Application for a non-material amendment following a grant of planning permission.

Unit:	—	House number:	21	House suffix:	—
House name:	—				
Address 1:	WILLOW WALK				
Address 2:	—				
Address 3:	—				
Town:	SPALDING				
County:	Lincs				
Postcode (optional):	PE11 1UT				
Description of location or a grid reference. (must be completed if postcode is not known):					
Easting:	—	Northings:	—		
Description:					
Full planning granted for 3 bed detached dwelling

Applicant Ref: - H116/11628/07 12/12/07 FULL
3 Bed detached dwelling with off road parking

Would like to increase the size of upstairs bedroom 1 (one) window to align with downstairs large window. Please see drawing 005 South Elevation and 001 ground floor and first floor layouts.

South Elevation

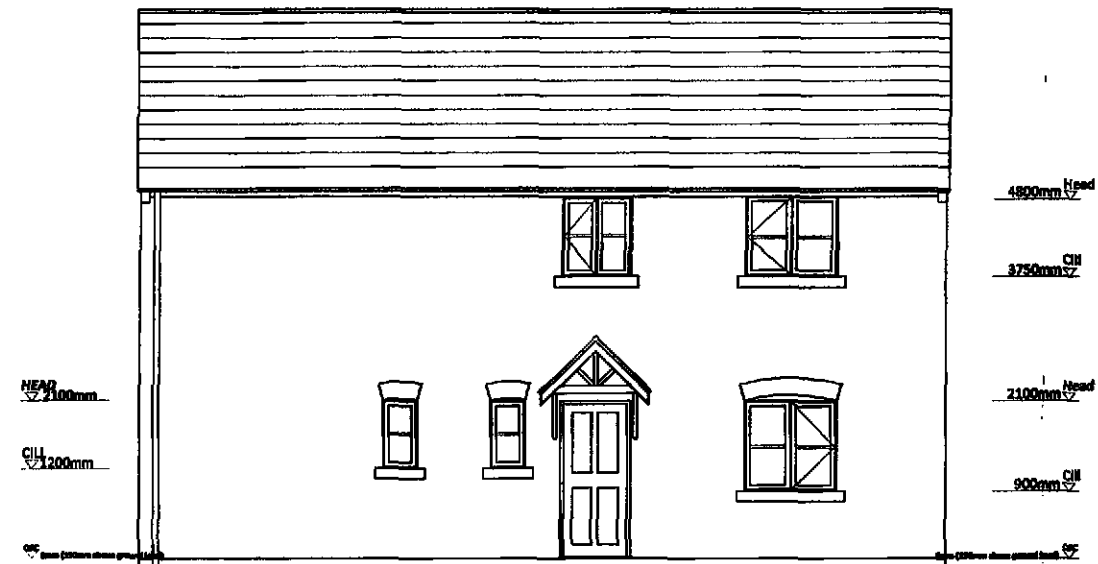
To increase amount of light into Bedroom one as there is now the inclusion of an en-suite in Bedroom one

Scale 1:50 & 1:100 Drg. no. 07/01/04  
Date December 2007

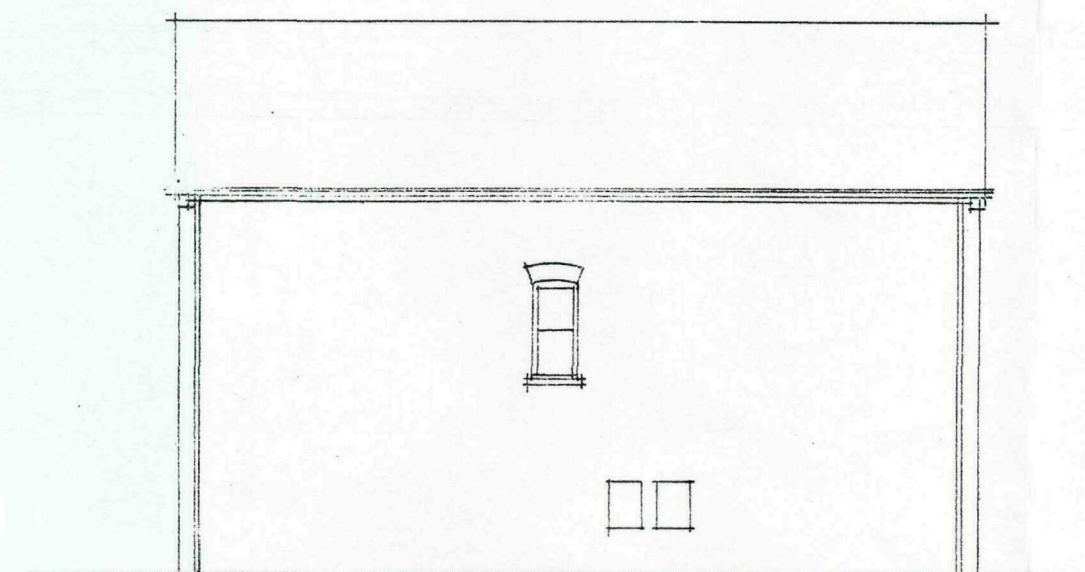
07/01/04 - Proposed New House Adj. to 21 Willow Walk, Spalding
